# 14160 STONE EAGLE PLACE

# GRADING, EROSION, & SEDIMENT CONTROL PLAN

EPC STORMWATER REVIEW COMMENTS  
IN ORANGE BOXES WITH BLACK TEXT

PCD FILE NO. **CDR2119**

14160 STONE EAGLE PLACE
GRADING, EROSION, & SEDIMENT CONTROL PLAN
COVER SHEET

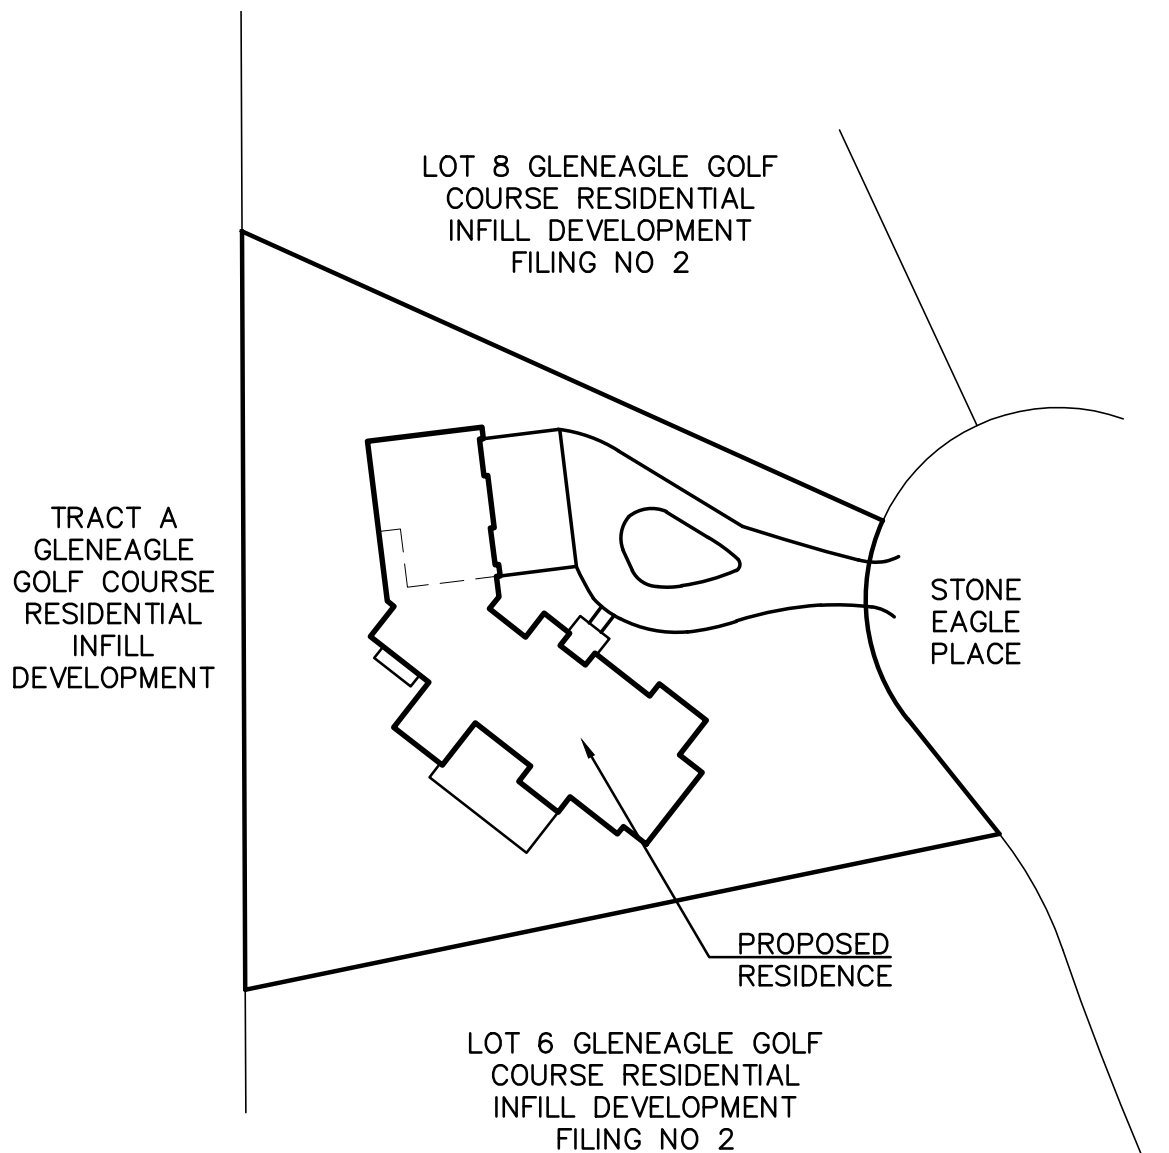
Item "i" - make a note about existing vegetation (in this case, the pre-disturbance vegetation).

Item "u" - make a note that locations of staging and stockpiles to be noted by contractor (if this is true, otherwise modify that statement as needed).

GRADING, EROSION, & SEDIMENT CONTROL PLAN  
EROSION CONTROL PLAN

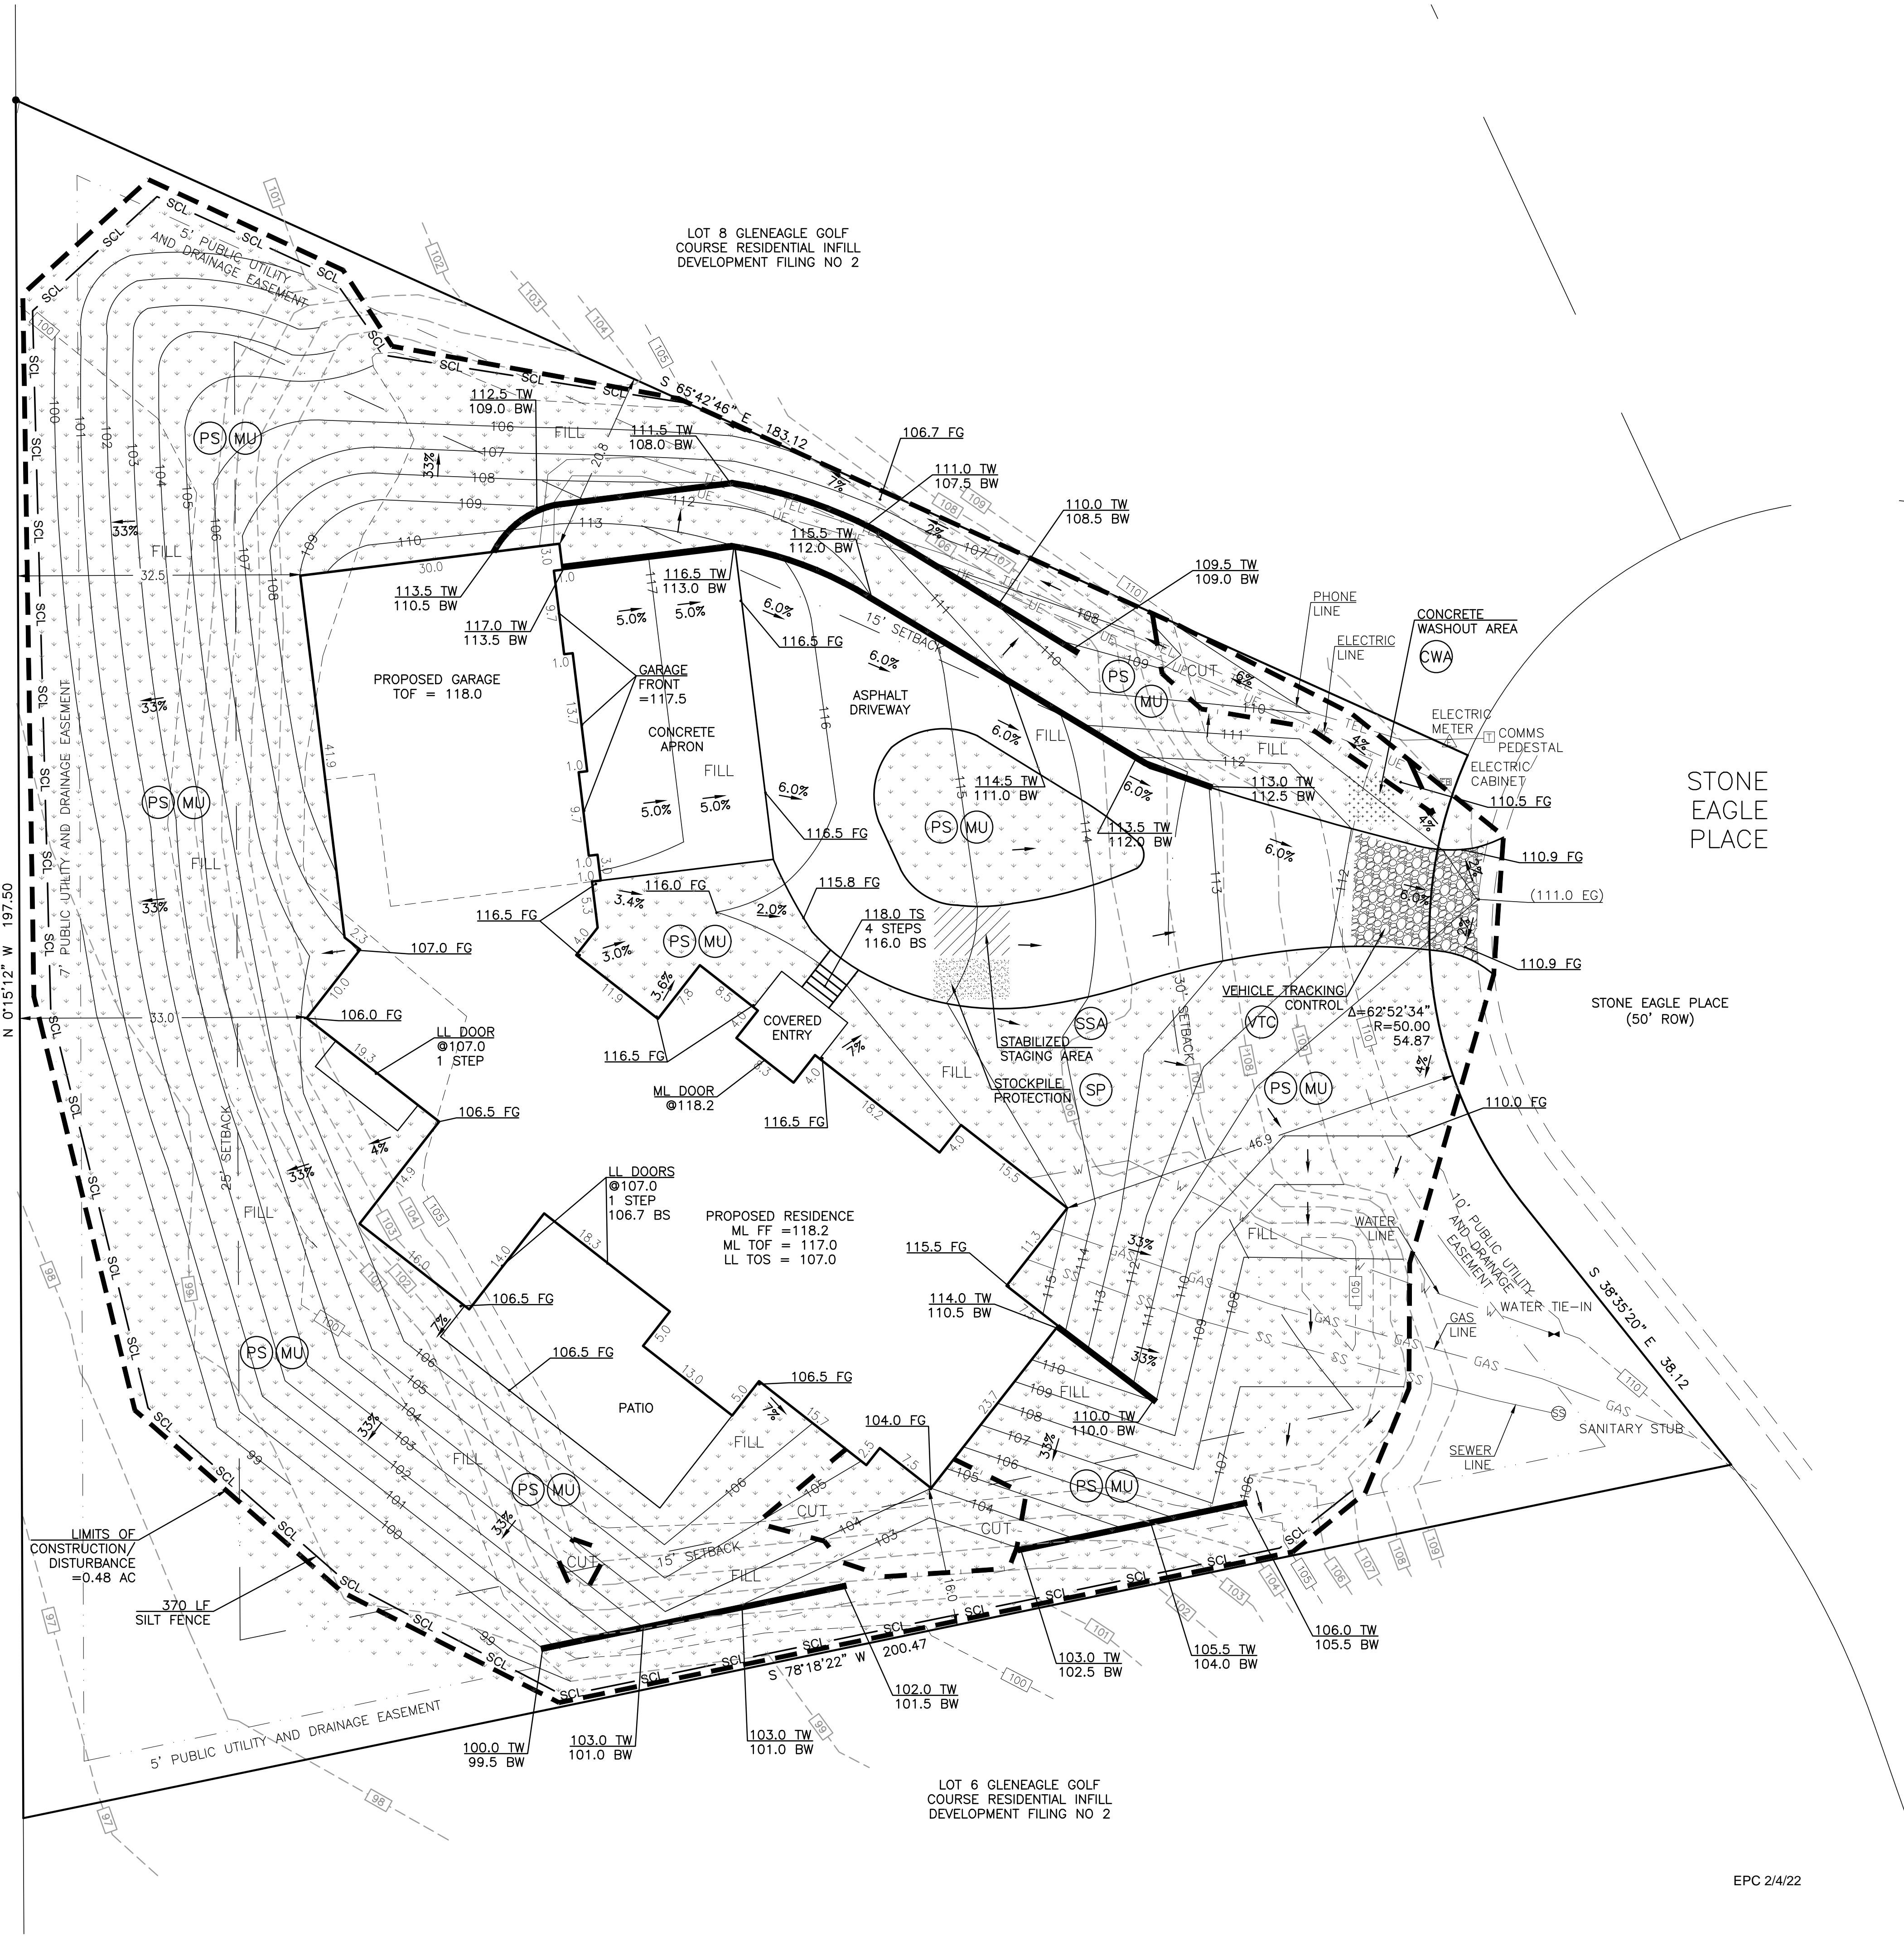
Please move retaining walls to be 7' apart for a 3.5' wall height per PPRBD code #5. Please call Lupe Packman at 719-313-6215 for any questions.

Items H and M. If "limits of disturbance" and "construction boundary" are the same, change to "limits of construction/disturbance" or otherwise show as separate line types for each on the legend and figure.

Item DD. Note: Regional Building Department permit required for all retaining walls greater than or equal to 4 ft in height. Typical comment for all retaining walls onsite.
